APPLICATION NO. 09AA-1011071011 PROJECT NO. 1003062
 PROJECT NAME SKYVIEW CENTER
 EPC APPLICATION NO.
 APPLICANT / AGENT SCOTT STEFFEN | PHONE NO. 823-1000
 ZONE ATLAS PAGE C-2
 (SDP for SUB), (SDP for BP), (FINAL PLATS), (MASTER DEV PLAN), (IR), (AA)

ONE STOP COMMENT FORM LOG

Re: Modifications to Amended Site Development Plan for Building Permit:
CVS at Indian School and Tramway

Re: Administrative Amendment Request: Proposed CVS at the Northeast Corner of Indian School and Tramway

TRAFFIC CIRCULATION LAYOUT

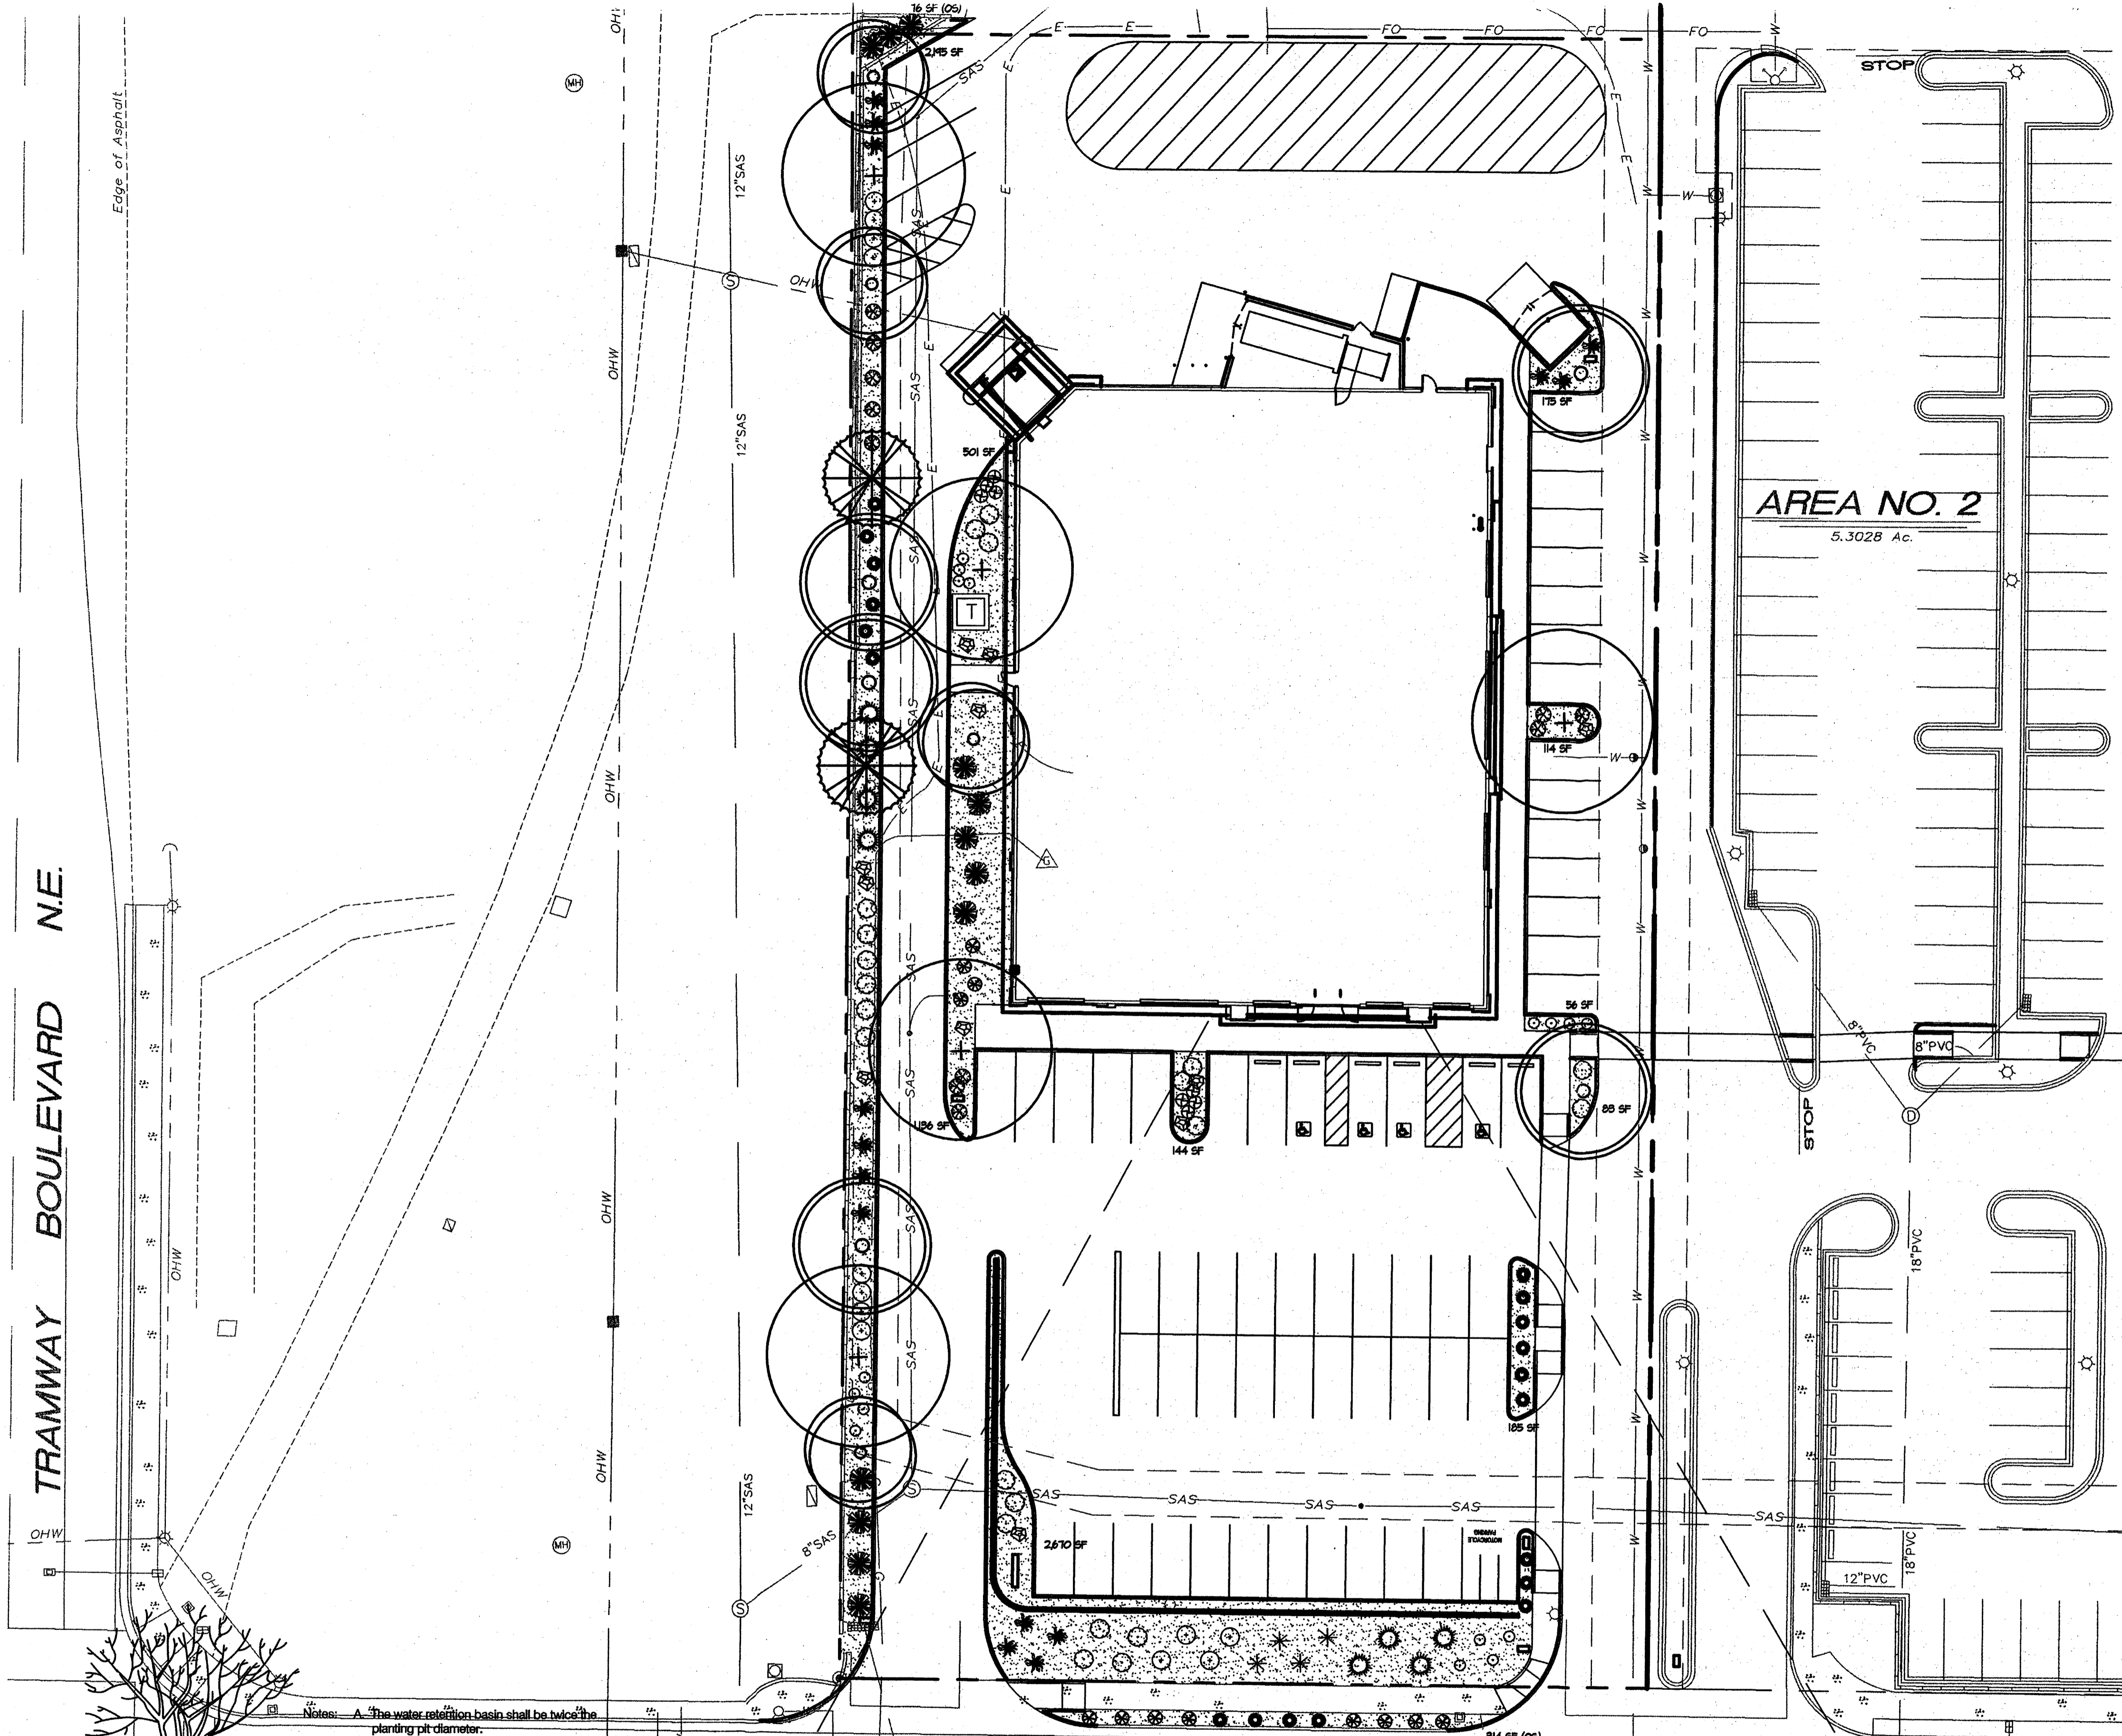
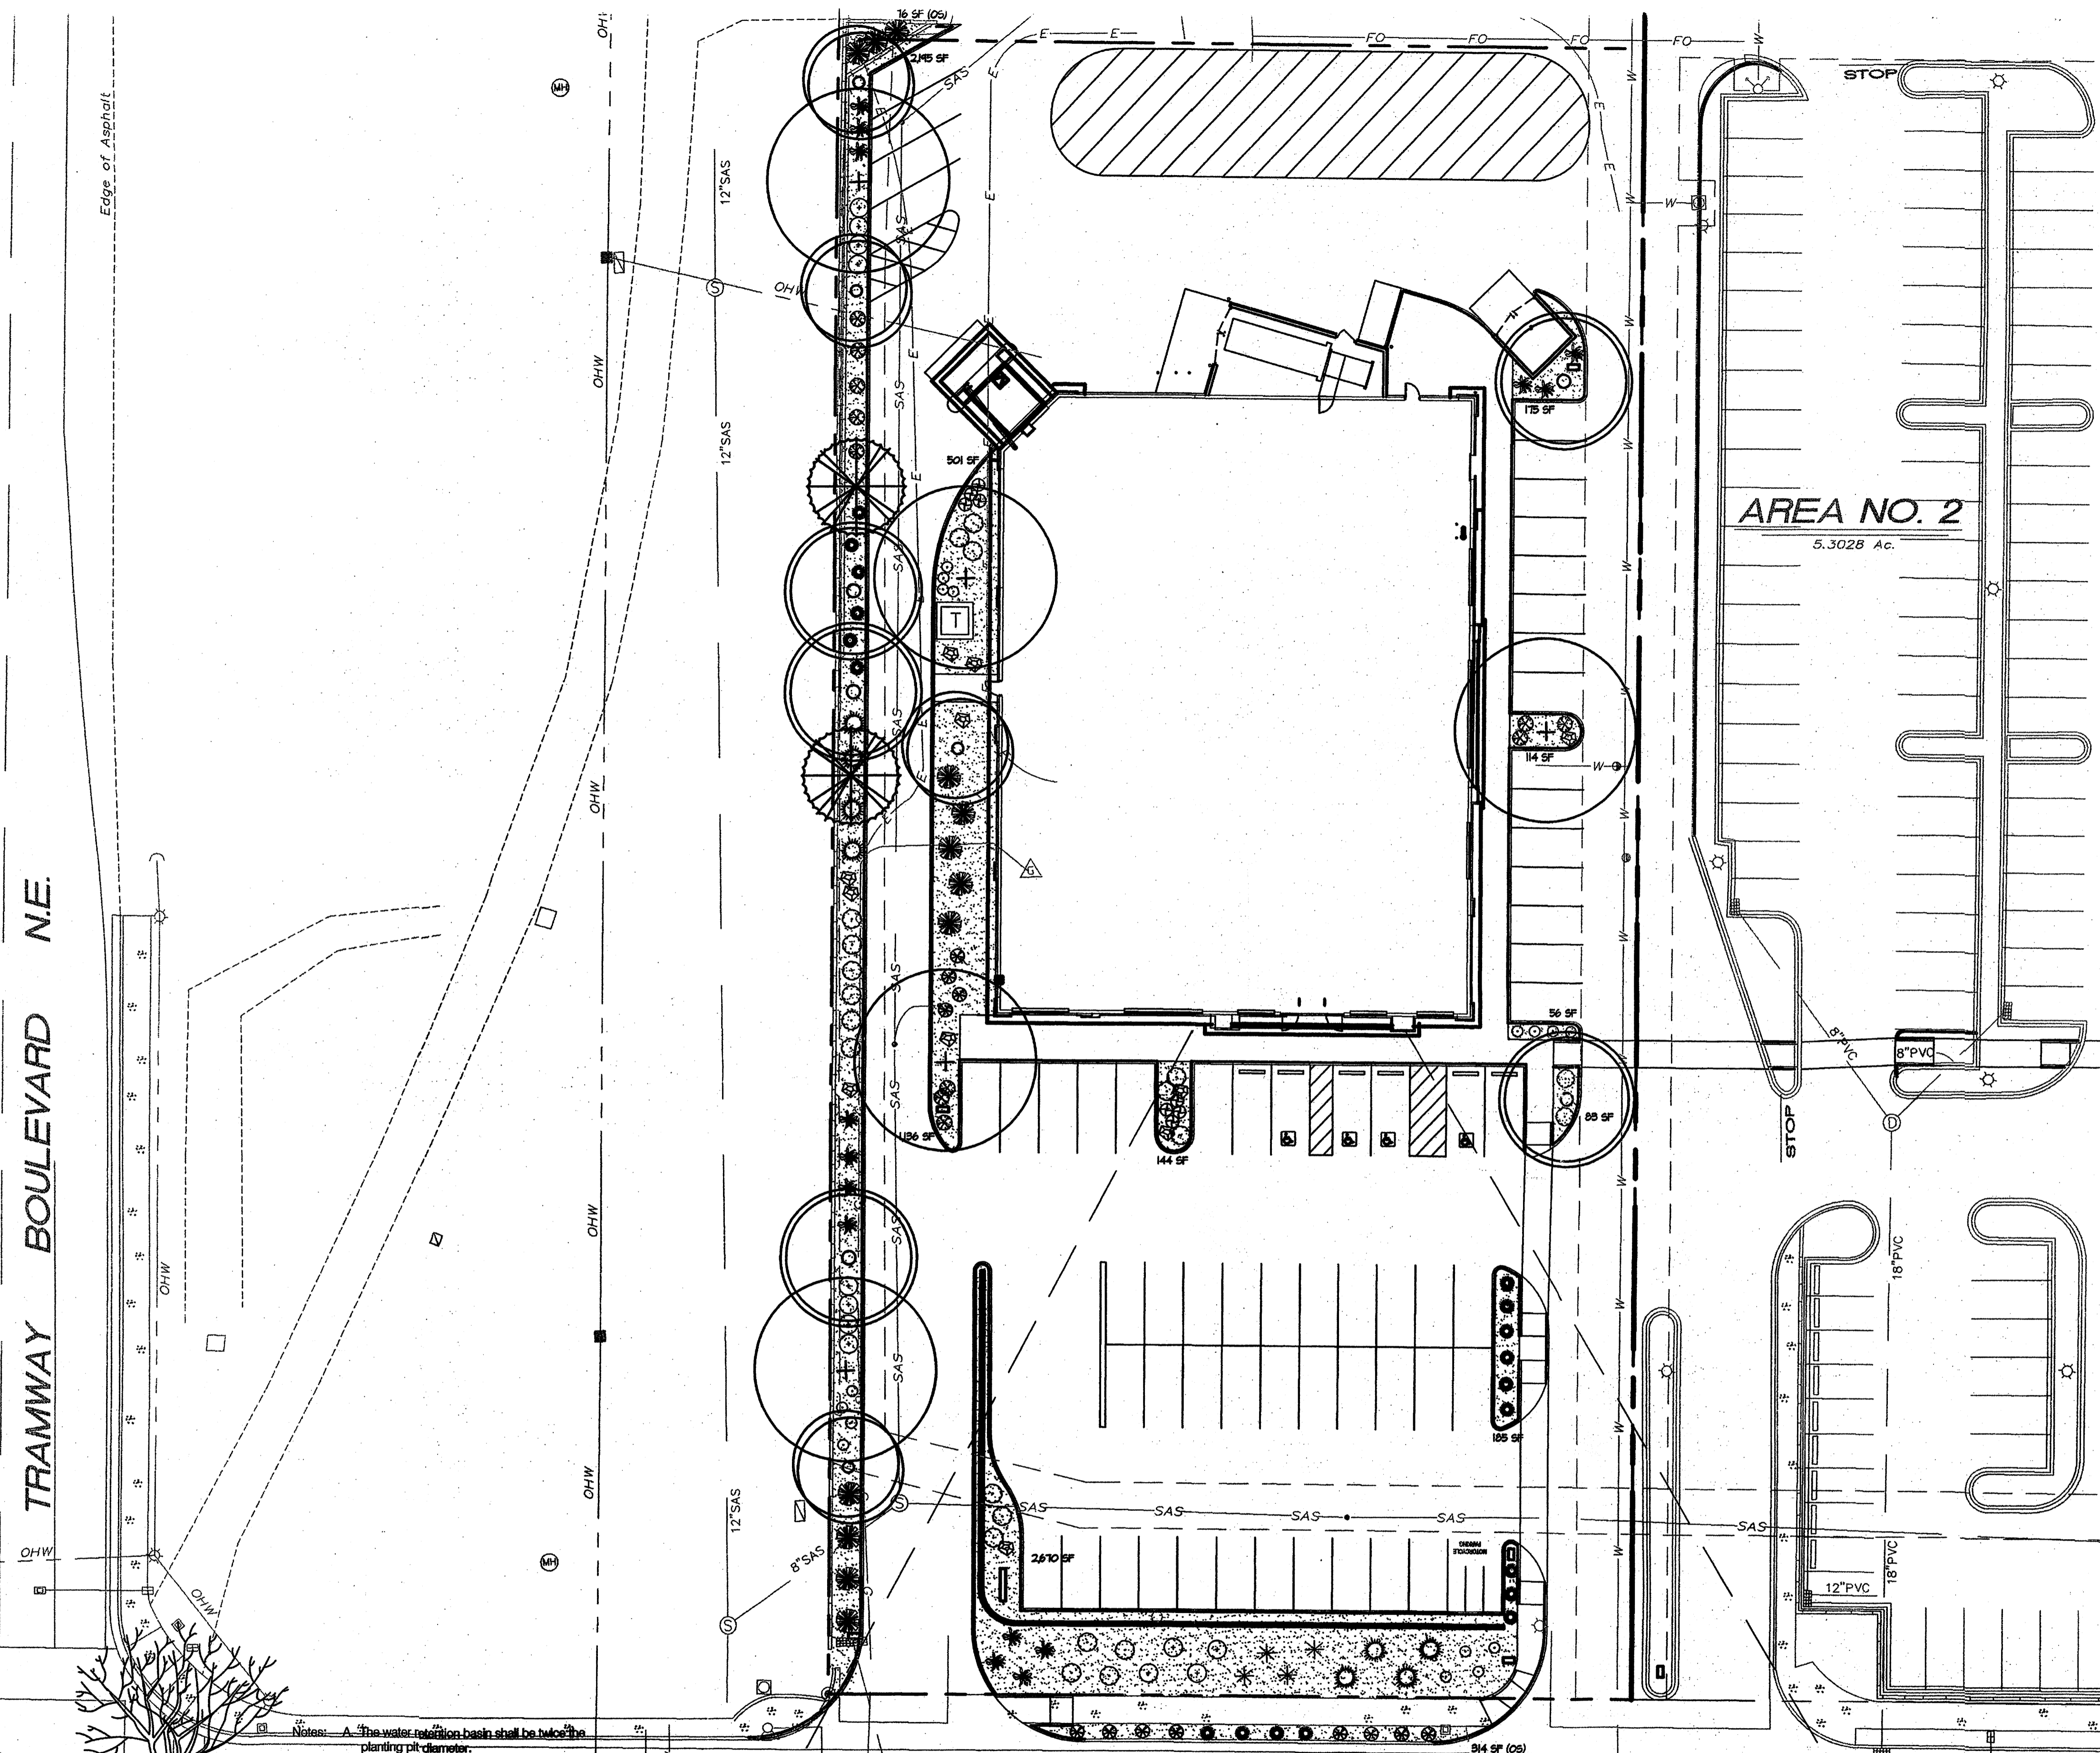
TRANSPORTATION DEV (505) 924-3990
 PLANS DISAPPROVED ~~TL~~ | DATE 8-5-09 | DATE
 PLANS APPROVED ~~TL~~ | DATE 8-21-09 | DATE
 1. PROVIDE CROSS ACCESS AGREEMENT COMMENTS. → AT PLATTING.
 ✓ 2. LABEL SITE DRIVES AS EXISTING. IF MODIFYING, CURB RETURN RADIUS SHOULD BE 25'.
 ✓ 3. STRIPE AREA BETWEEN PROPOSED CWS AND EXISTING 9000 SQ. FT. BUILDING TO PROVIDE FOR DEFINED DRIVING AISLES (AS DISCUSSED).
 ✓ 4. CHECK W/ FIRE CONCERNING WIDTH OF DRIVE-THRU LANE
